Application for a non-material amendment following a grant of planning permission.

Erection of a multi-franchise car dealership (sui generis use) with offices (B1 use class), workshops (B2 use class) and car storage (B8 use class), together with car parking, cycle parking, boundary treatment, landscaping, lighting and access.

Reference number:	<input type="text" value="6/2019/1411/MAJ"/>
Date of decision	<input type="text" value="04/09/2020"/>

Drawing Title			
Workshop C and Showroom Elevations			
Drawn	Date	Checked	Scale @ A1
RGH	SEP 2019		1:250
Job No	Drawing No	Revision	Note
2018-22	C-240	H

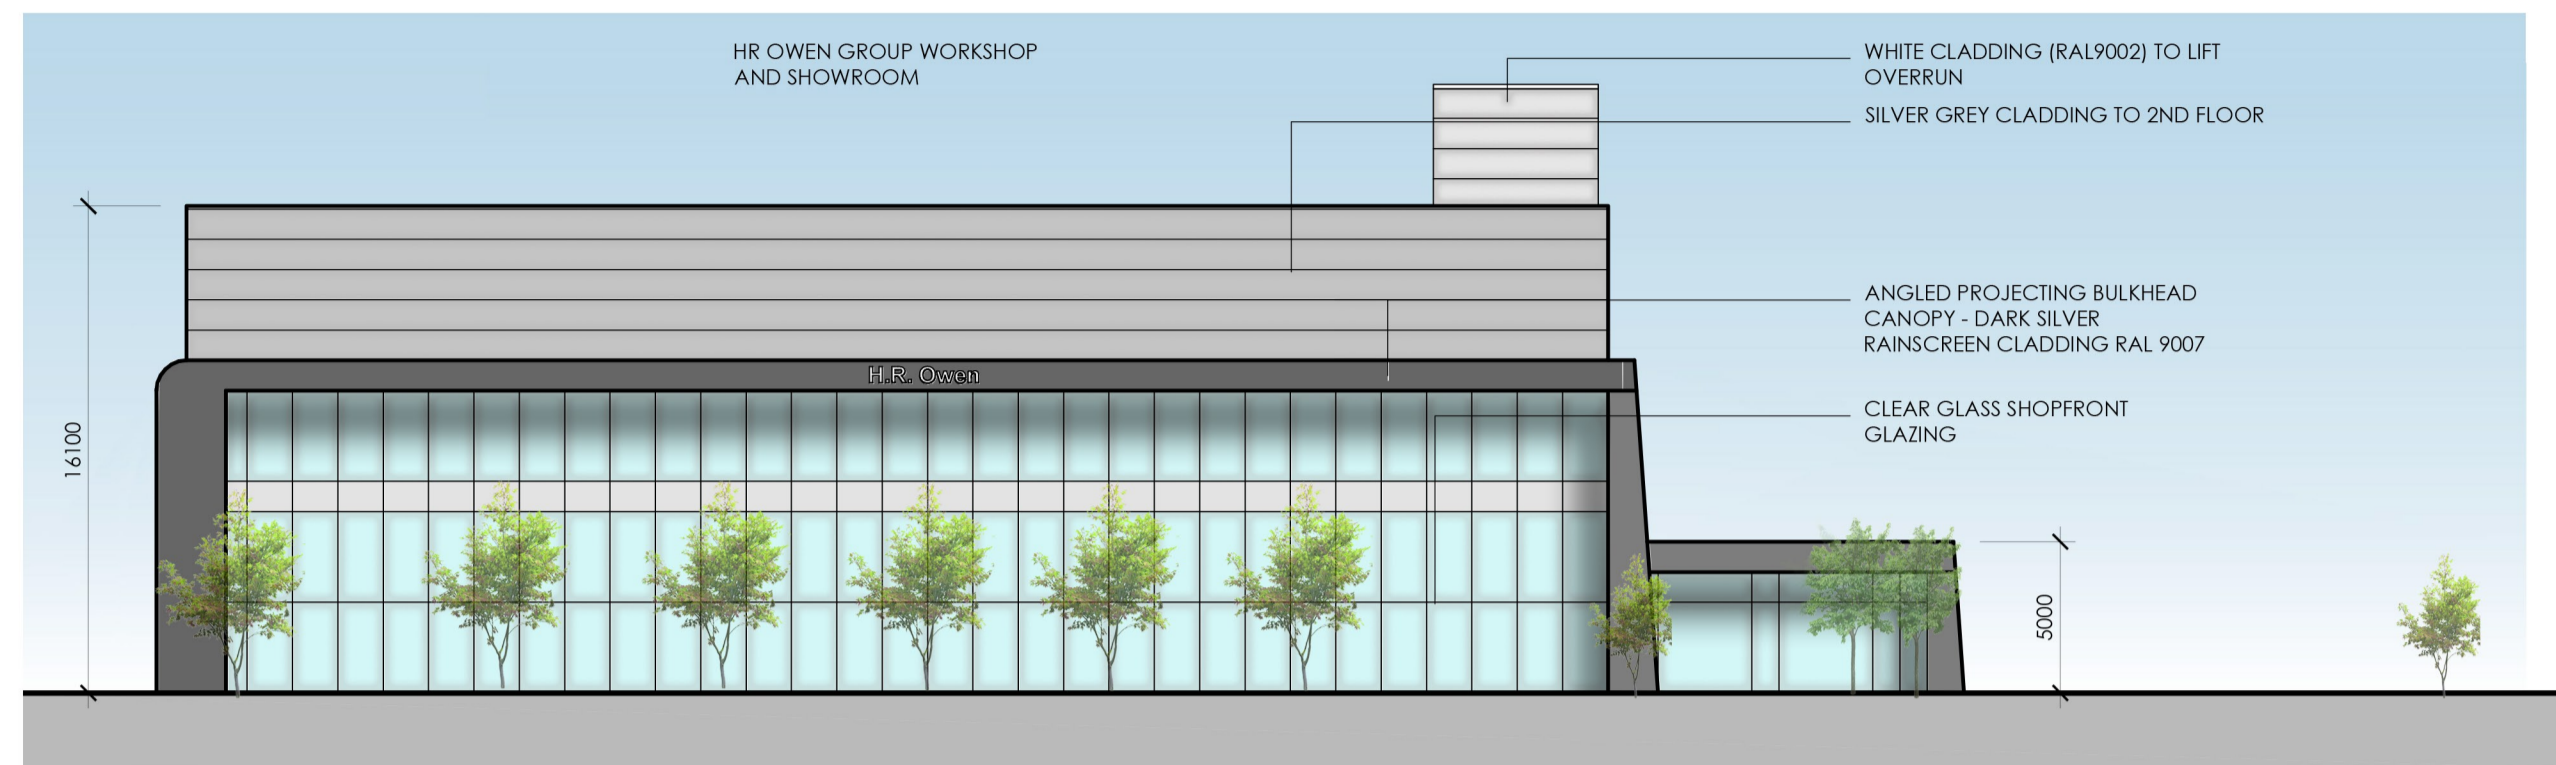
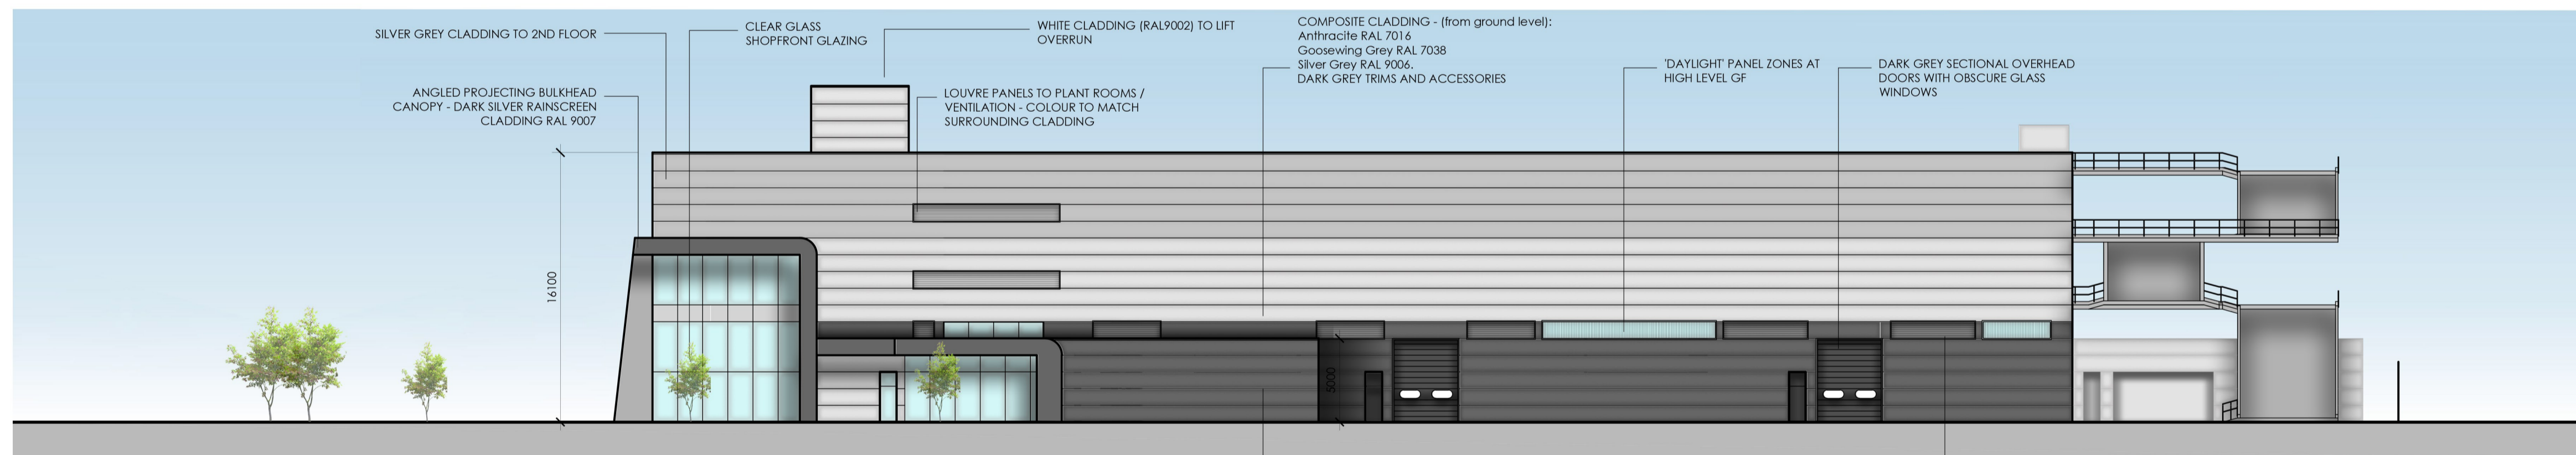
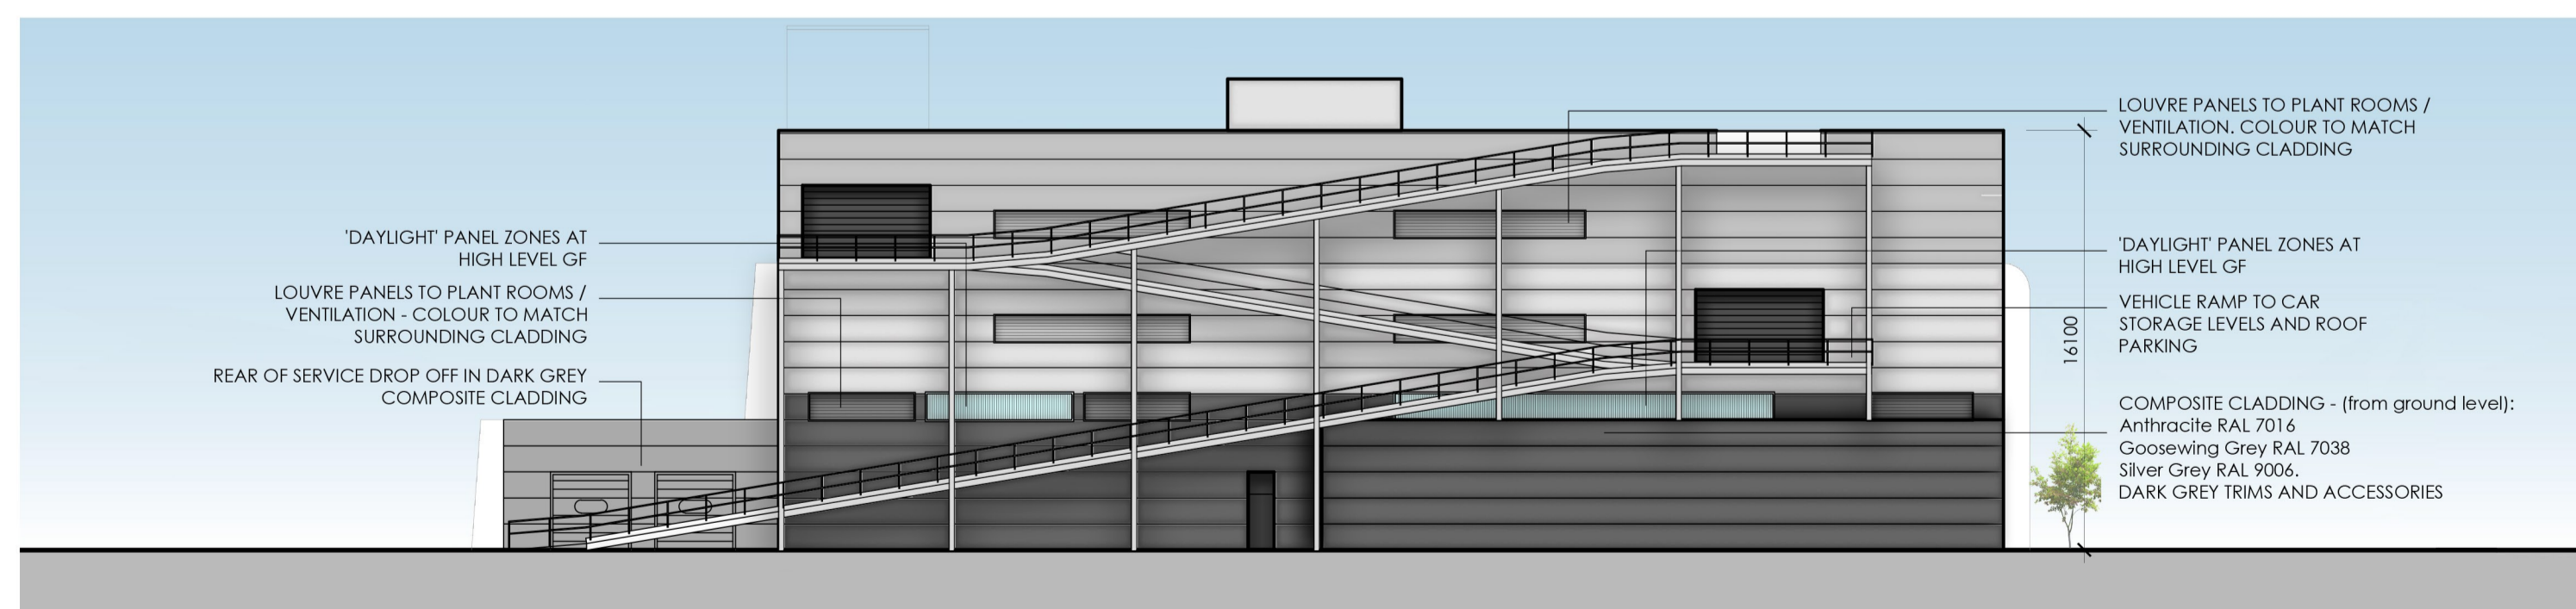
- Service 'Drop-Off' area increased in length
- Roof over service 'Drop-Off' area amended to suit updated layout
- Location of daylight panels to workshop amended
- Locations of Louvre panel openings amended
- Open mesh cladding omitted and replaced with solid silver grey cladding
- Plant room for mechanical ventilation added
- Lift over-run height amended
- Valet building rotated and re-positioned, and reduced in height
- Waste Management compound relocated to new position adjacent to substation
- Substation and switchgear housing rotated
- Minor adjustment to position of West Building and front elevation facing Mosquito Way
